SITE DEVELOPMENT PLAN DP-2 SITE PLAN

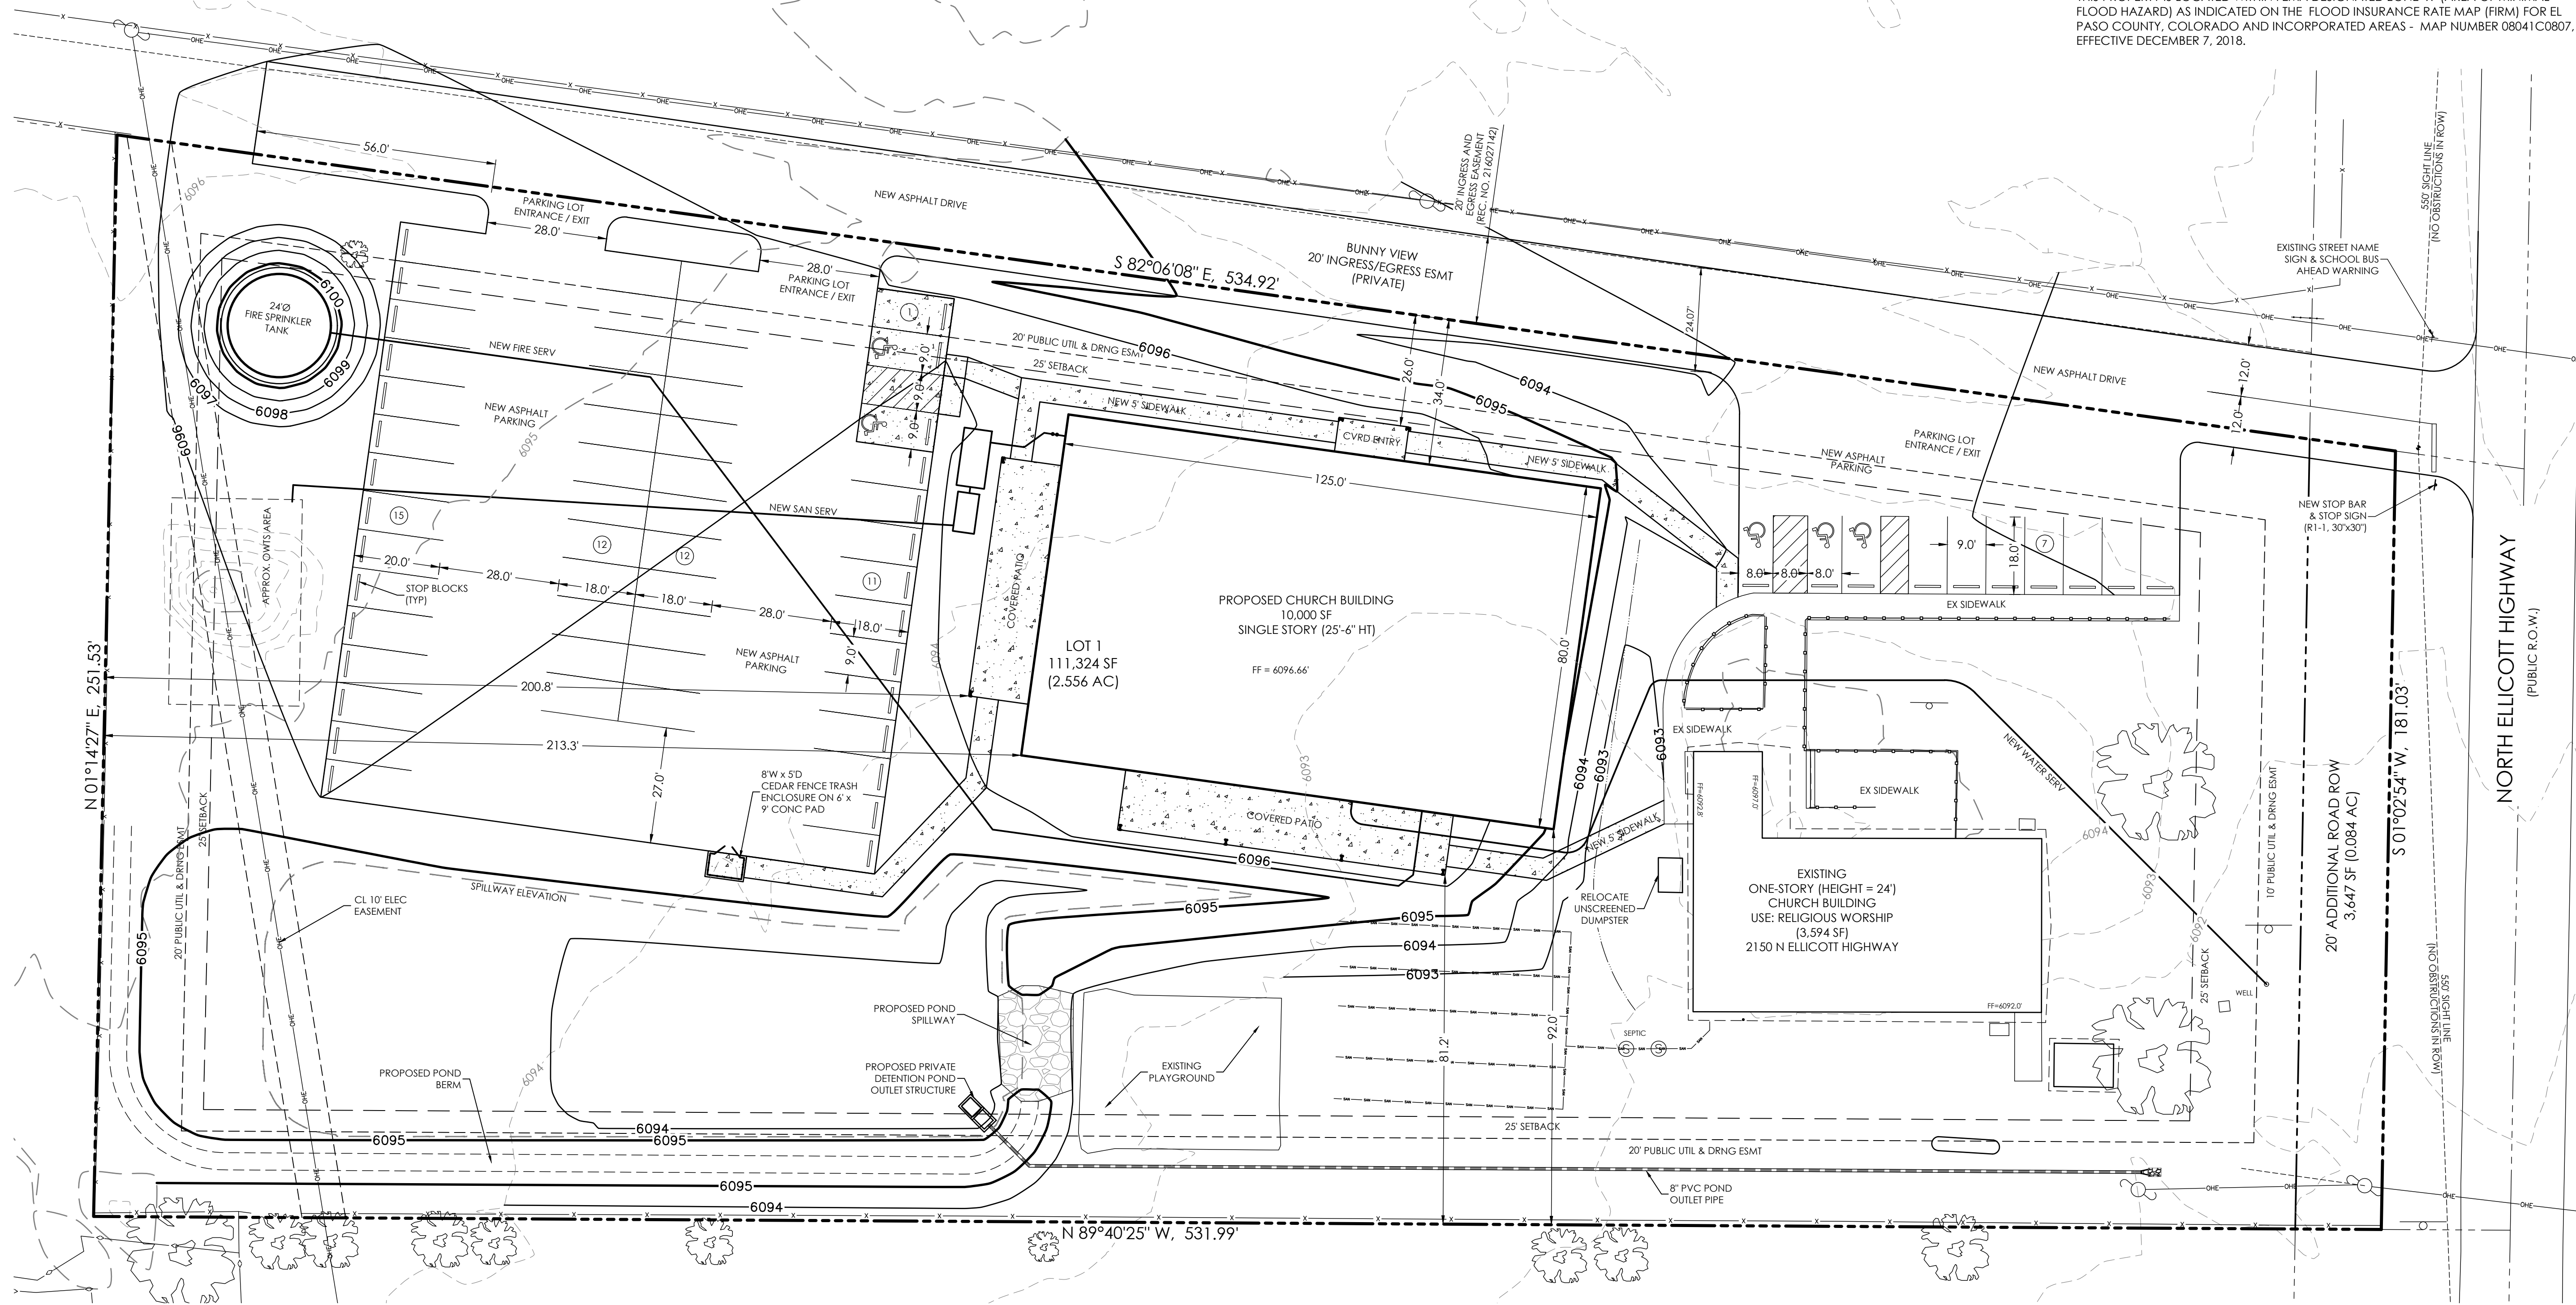
Current access utilities a constructed driveway along the north side of site which is located on adjacent property. A meeting was held with the adjacent owner who has agreed to allow an easement over the existing drive for access to the church facility. The agreement is not final yet, but will be provided when finalized.

Provide easement for staff review.
